ENCROACHMENT PERMIT AGREEMENT FOR IMPROVEMENTS  
WITHIN 20' MUTUAL ACCESS EASEMENT

WHEREAS, the INTERNATIONAL CHURCH OF THE FOURSQUARE GOSPEL ("CHURCH") and AHMET & MARTHA TIRYAKI & JASON M & COLLEEN BUCHANNAN & ROB & BANU MCKINLEY (AJR) possesses a 20' mutual access easement within **Lot H-1, La Questa Subdivision**, as the same has been filed for public record in Bernalillo County, New Mexico, on **3/3/2000 in book A9, page 924, as document # 2000021020**; and

ENGINEER'S SEAL 	ZIA PARK HOMES GRADING AND DRAINAGE PLAN Rio Grande Engineering 1806 CENTRAL AVENUE SUITE 201 ALBUQUERQUE, NM 87106 (505) 872-0999 MAY 2013	DRAWN BY WCMJ DATE 5-07-13 2721-LAYOUT-2-05-13 SHEET # JOB # 2721
---------------------	--	---

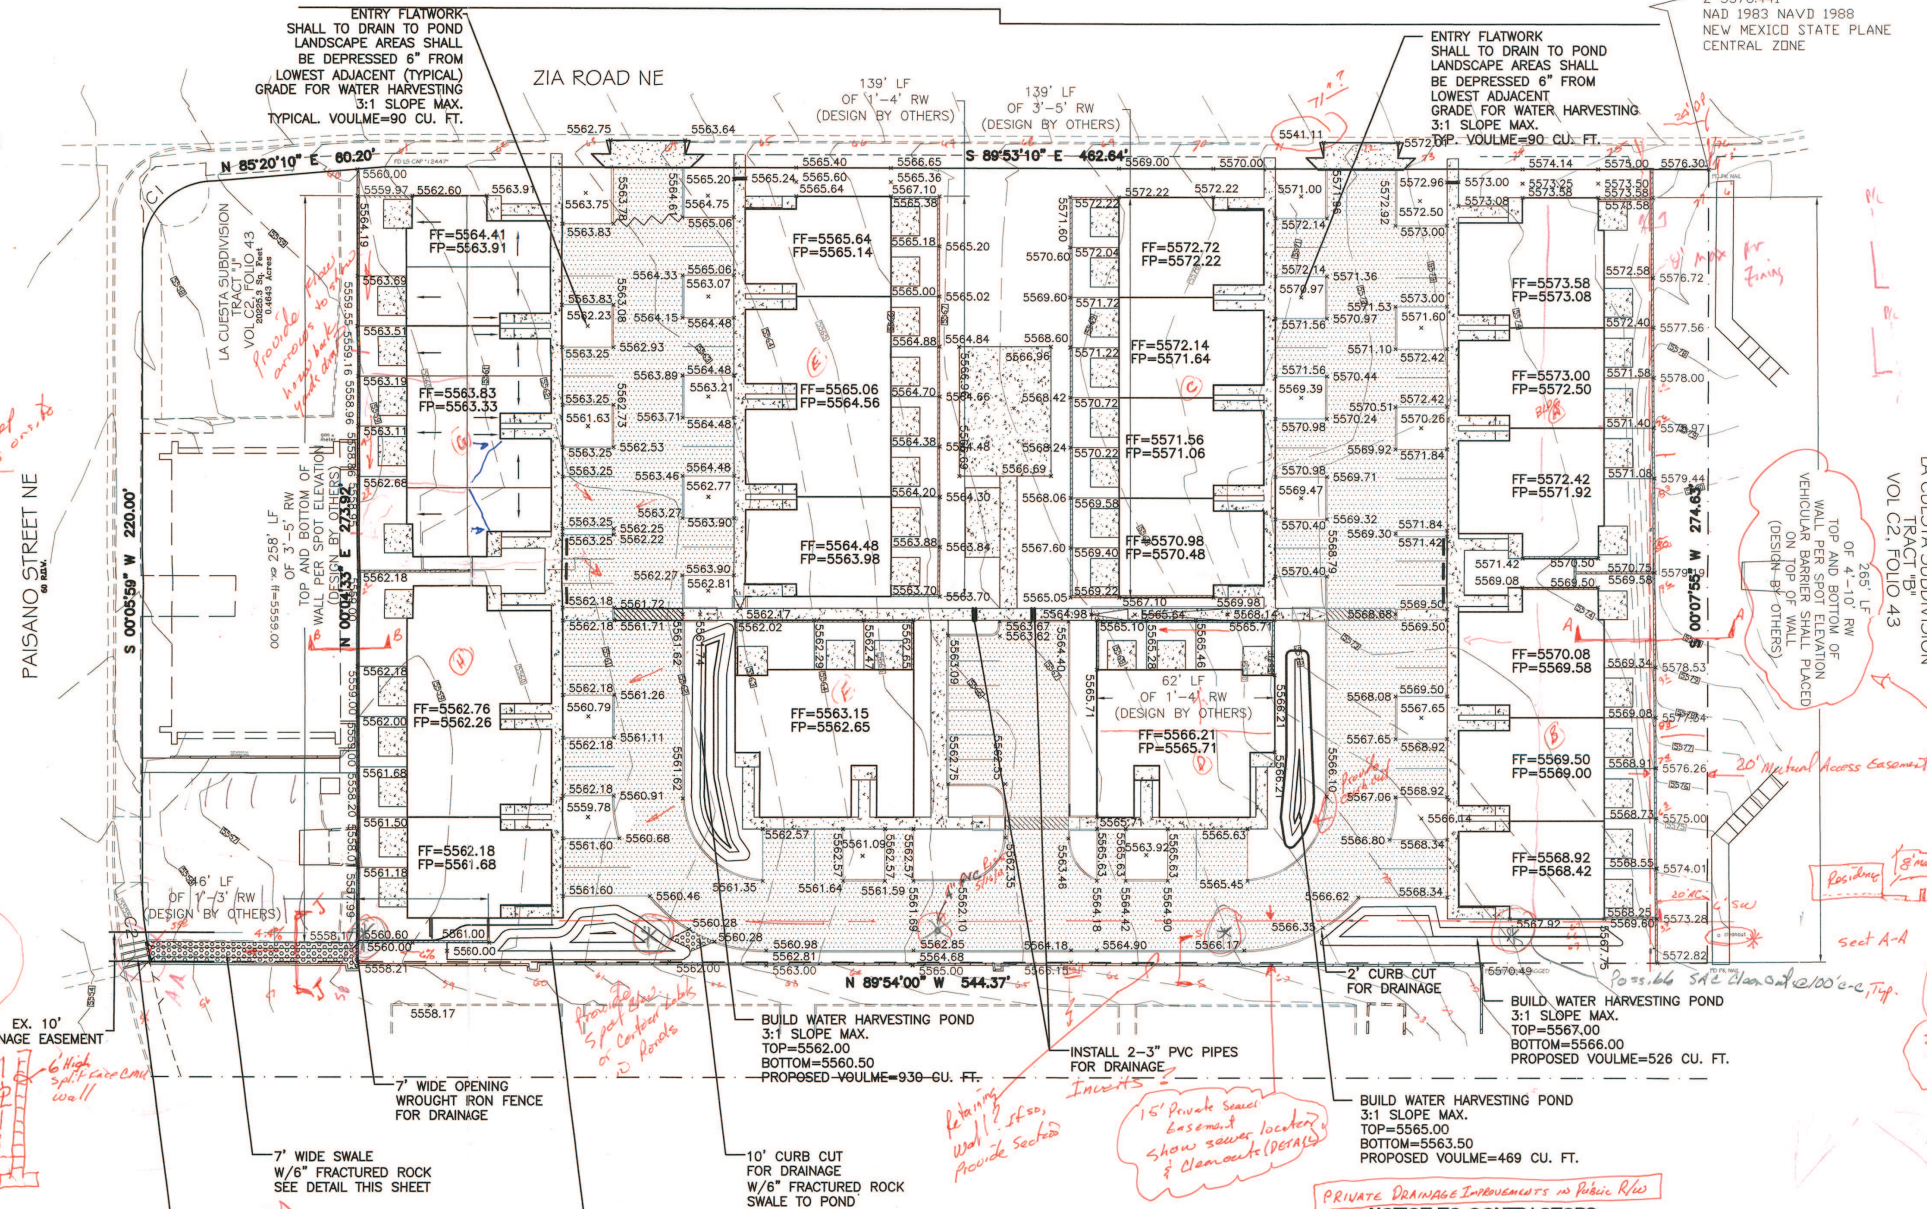
Grading Plan calls for invert to divert runoff from flowing over top of wall.

What is the offset distance from the wall to Easement?

MINIMUM ASPHALT WIDTH OF 16' MUST BE MAINTAINED
